**Application No:** 21/02231/F

**Proposal:** Change of Use-Stable Block to Dwelling House

**Location:** The Stables, Main Street, Wendlebury, OX25 2PR

**Objection by:** Mr Michael Harris

Client <b>Mr &amp; Mrs Lewis</b>	Title <b>Proposed Plans</b>	DRAWINGS <b>1/5</b>
Project <b>The Stables Main Street Wendelbury OX25 2PR</b>	Scale <b>1:100</b>	Drawing No <b>ILEWIS2021/24</b>

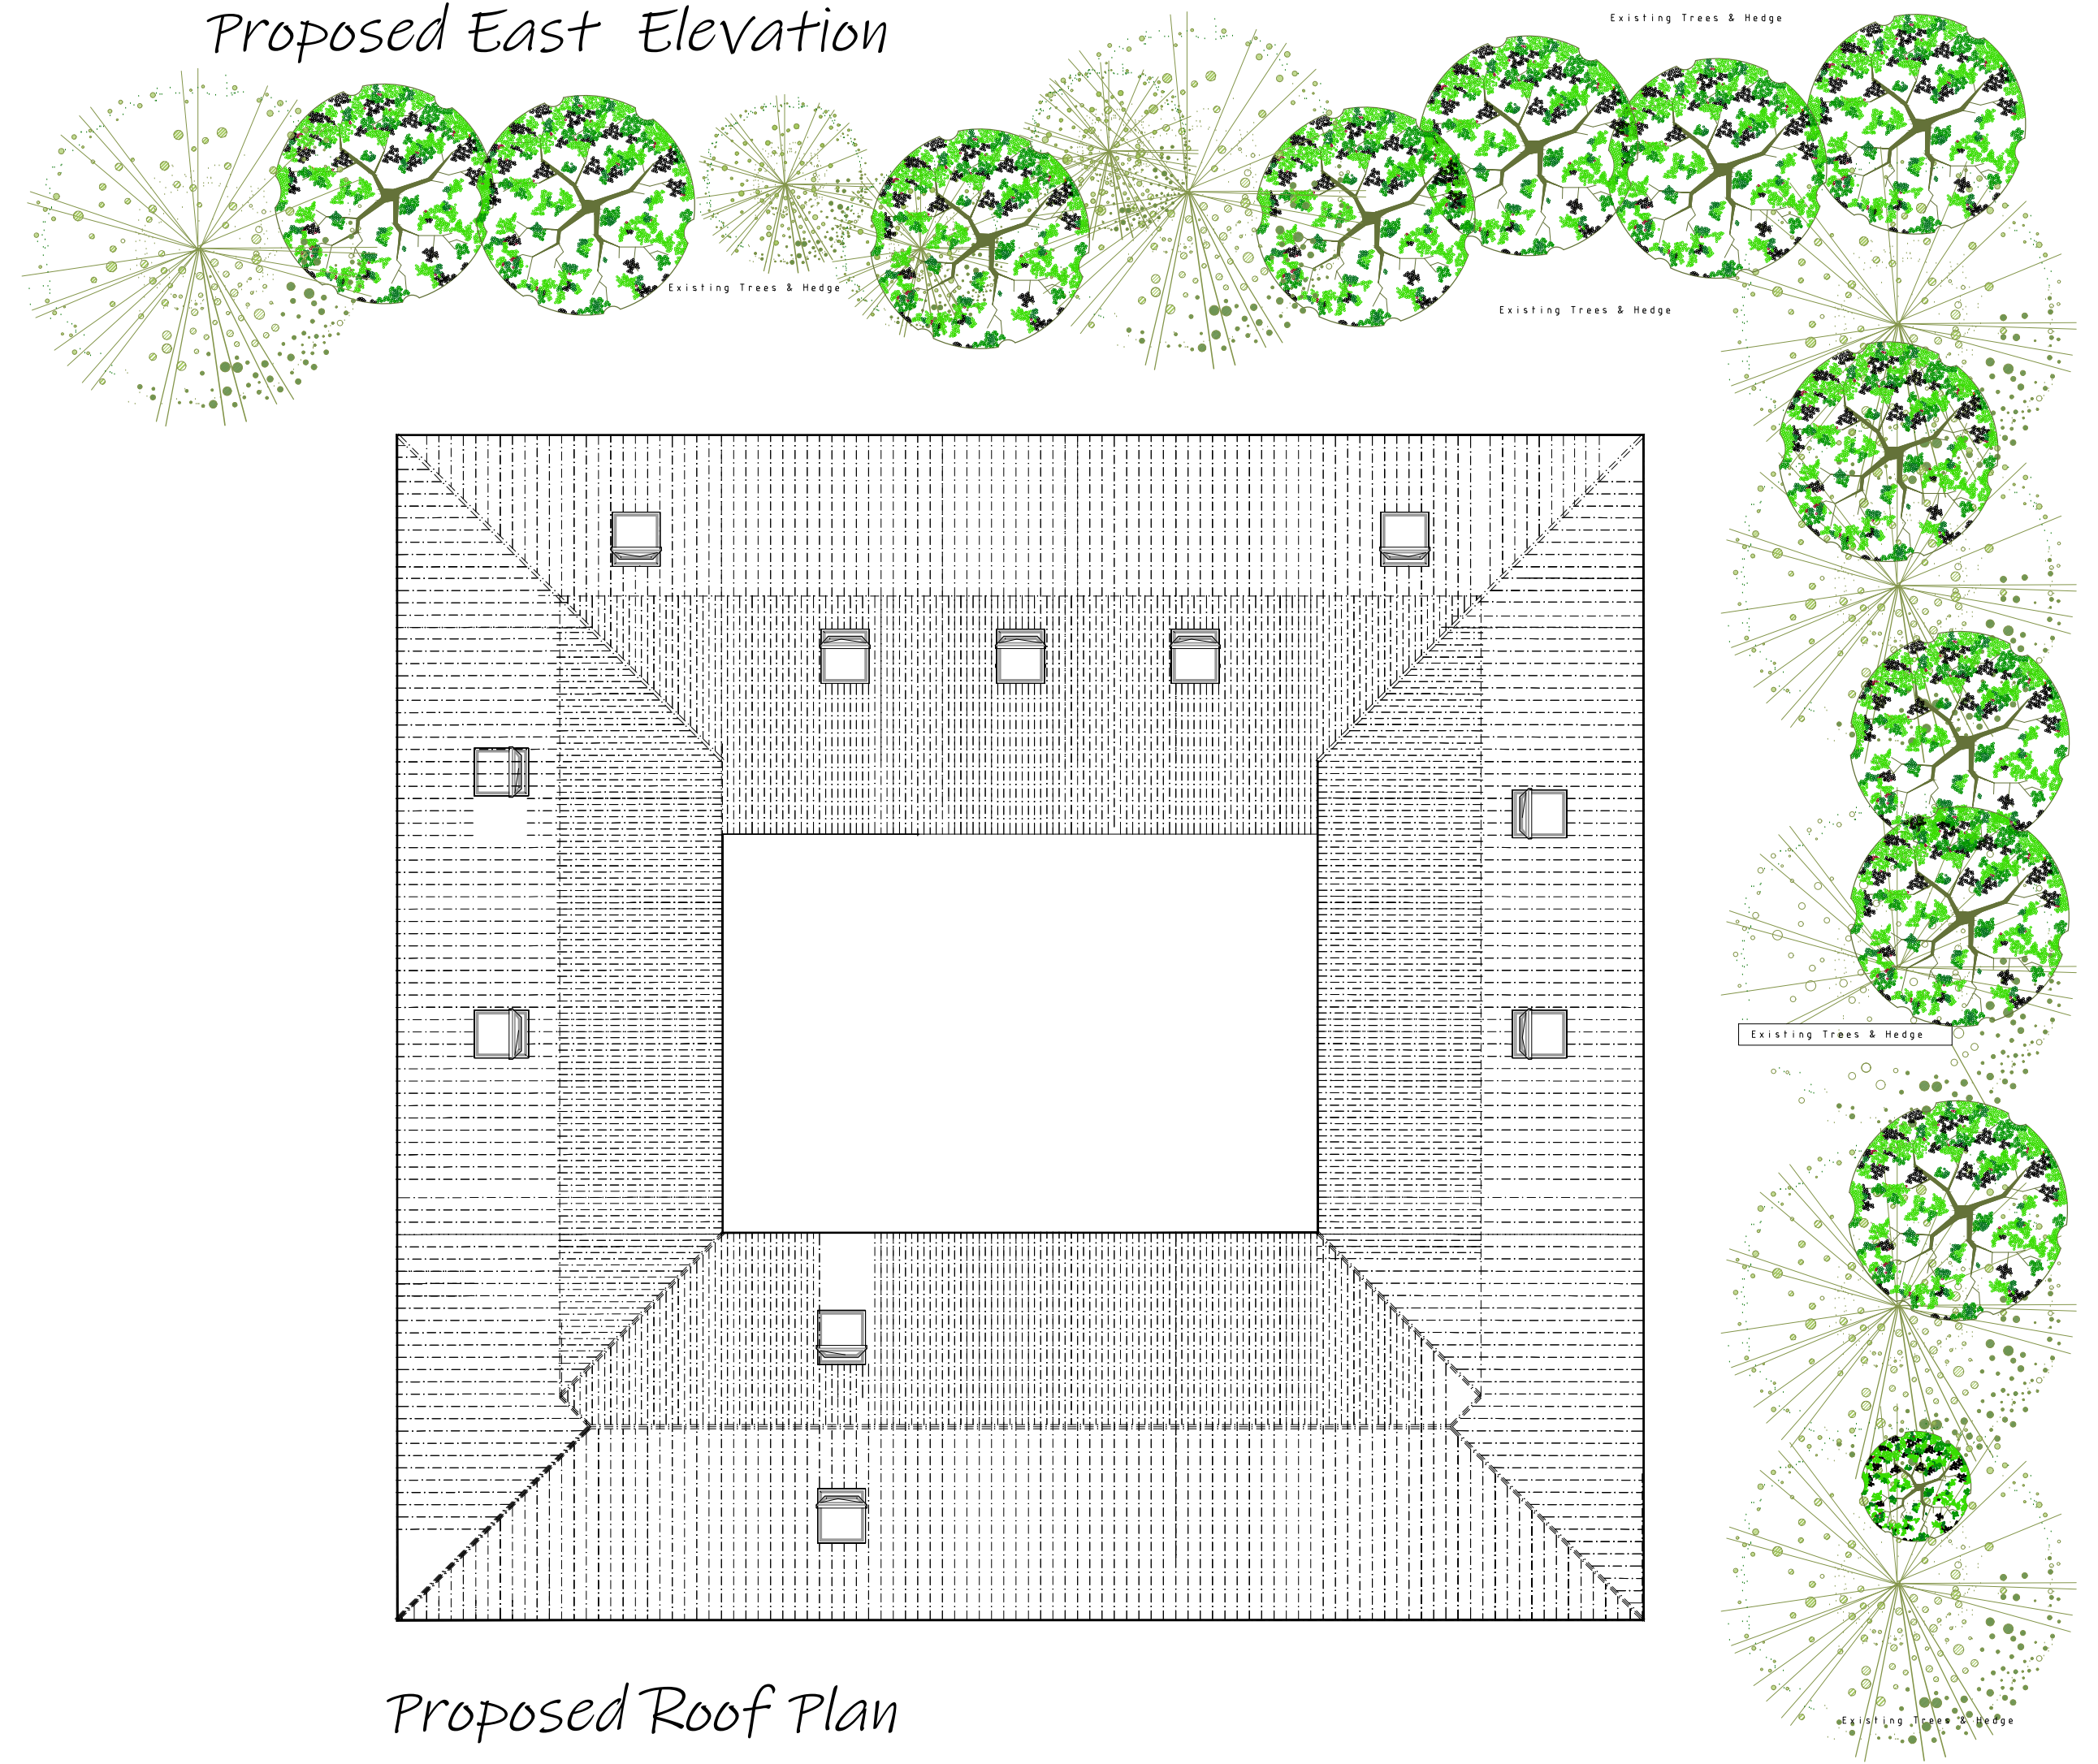
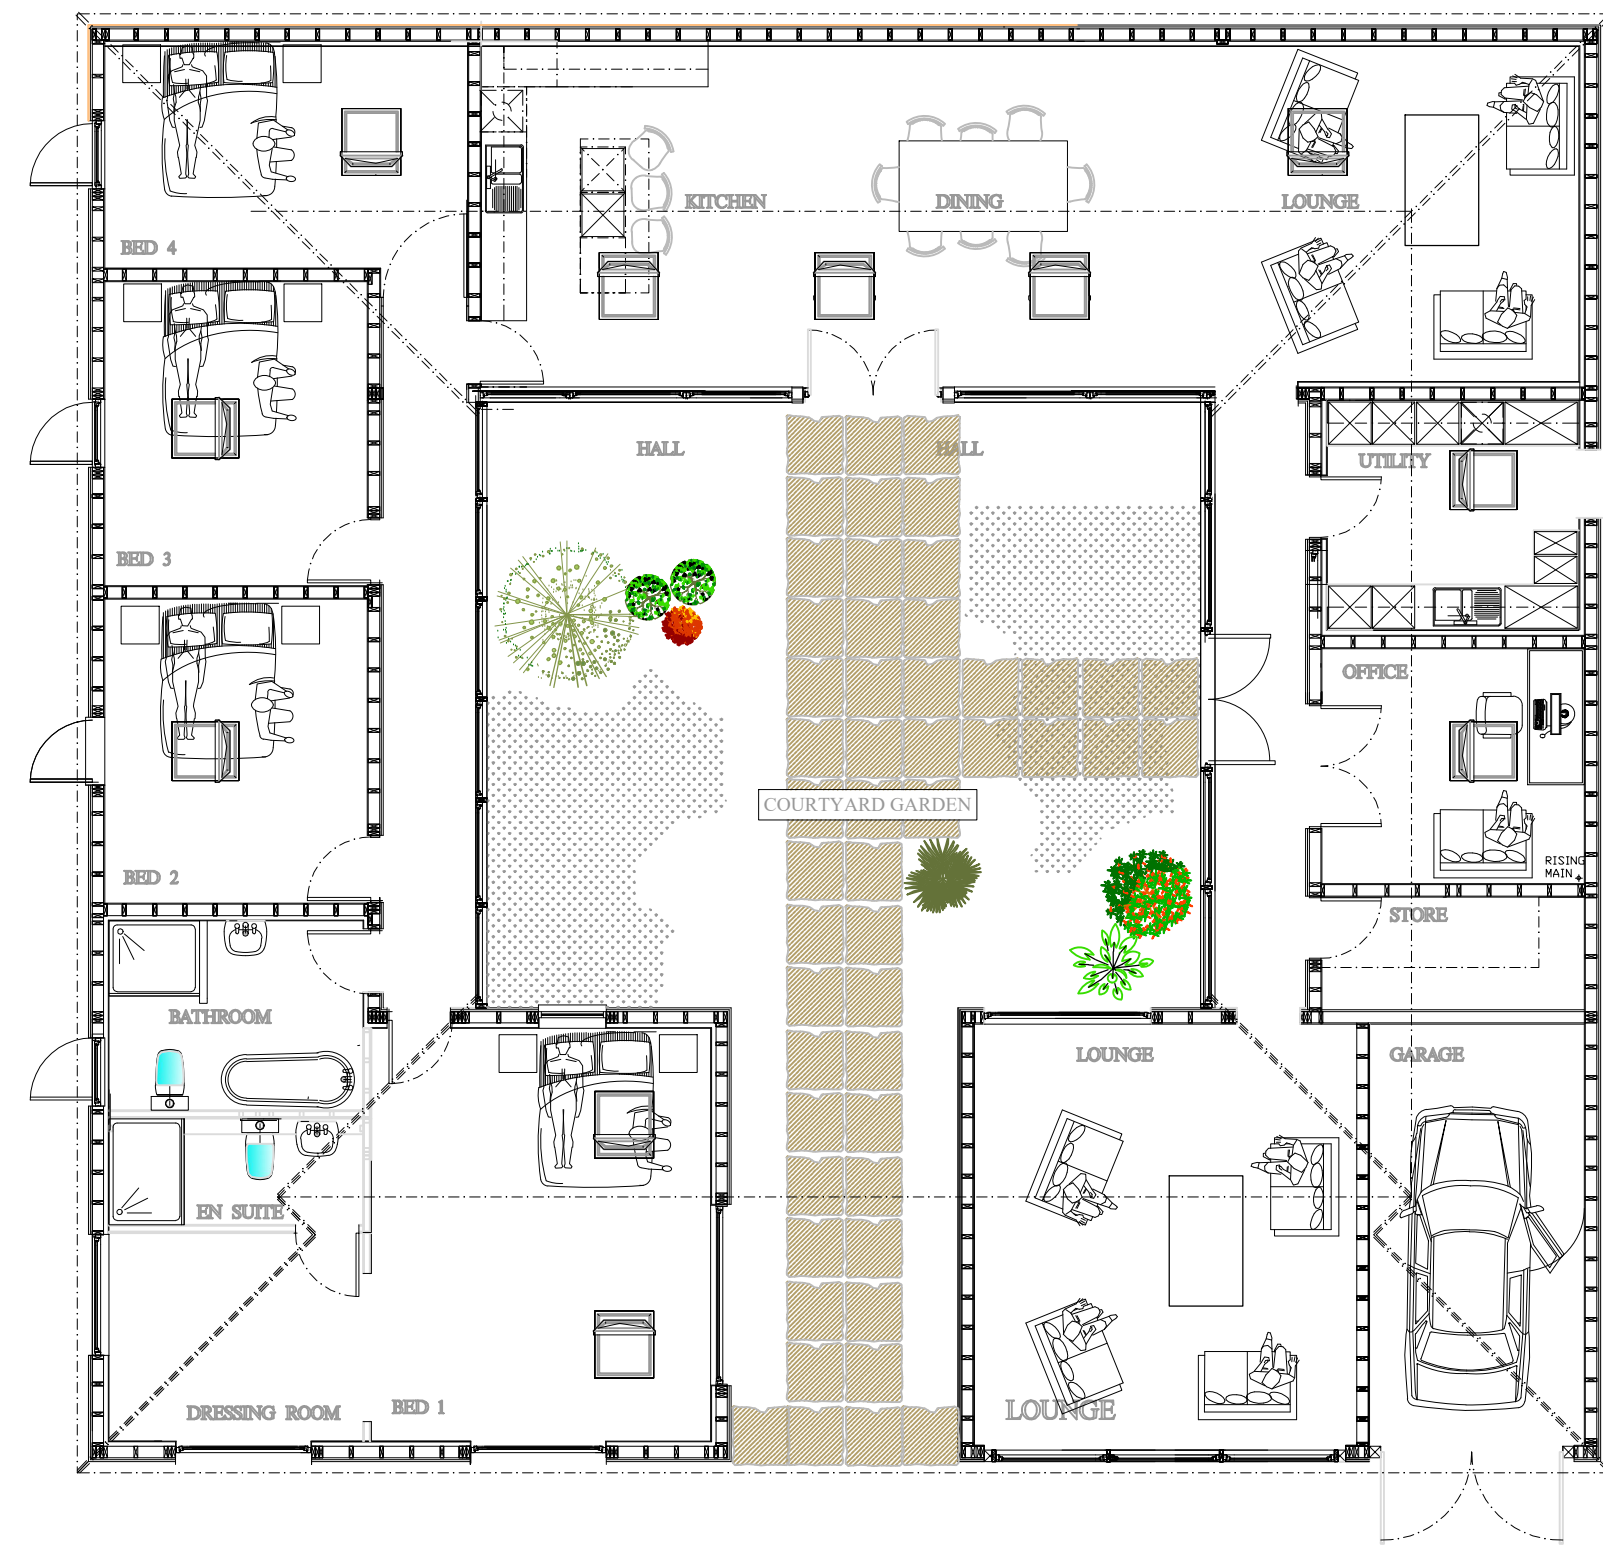
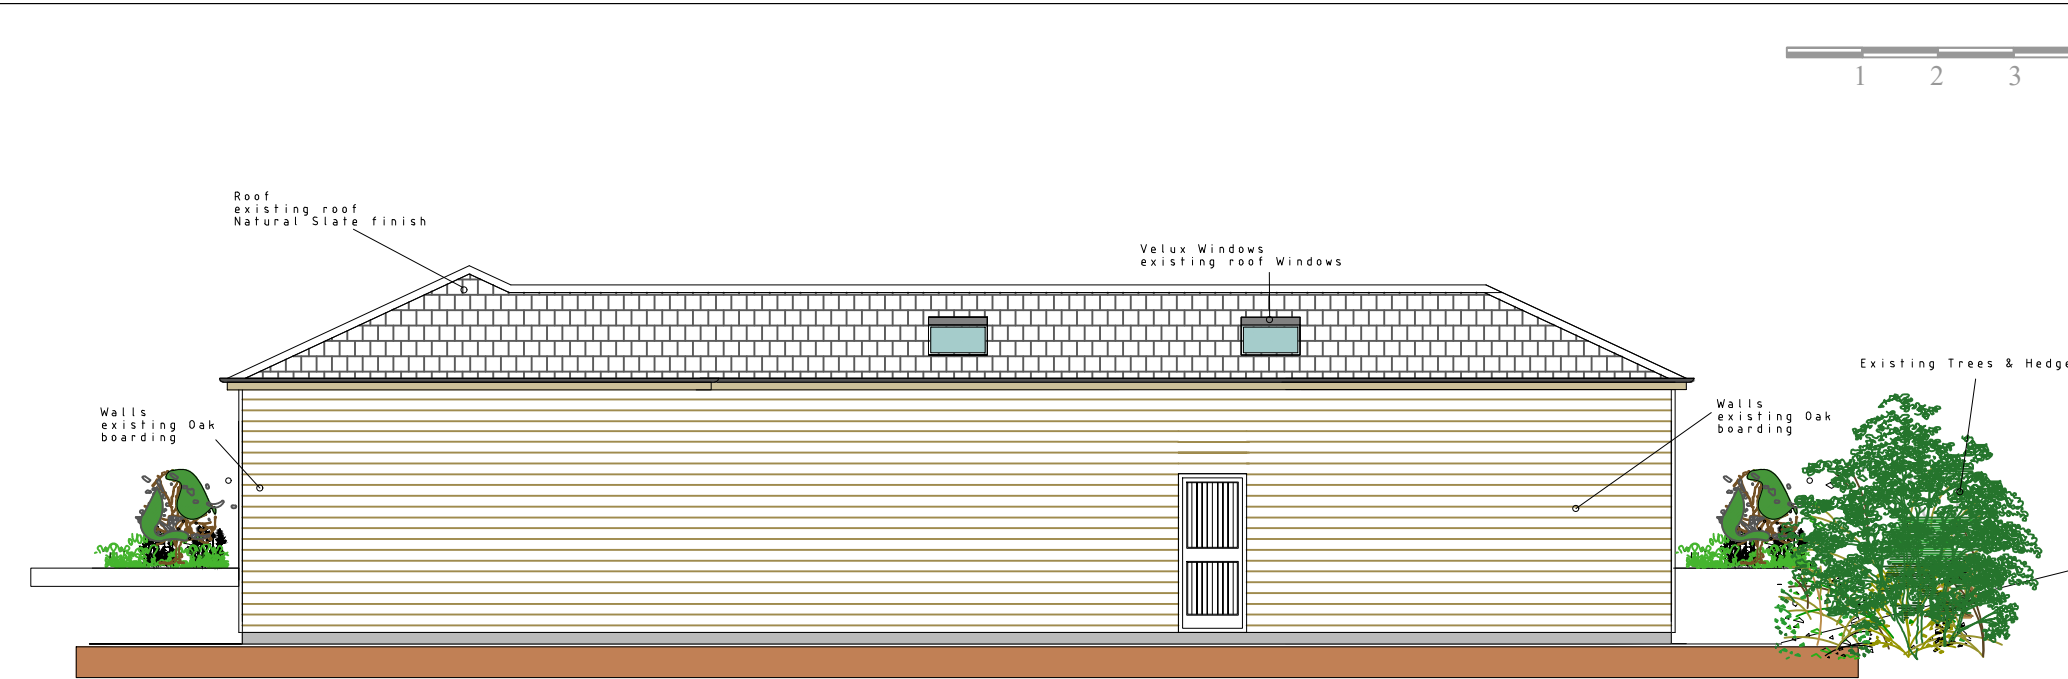
From the outline plans it appears that this application is more than a change of use but rather a complete rebuild.
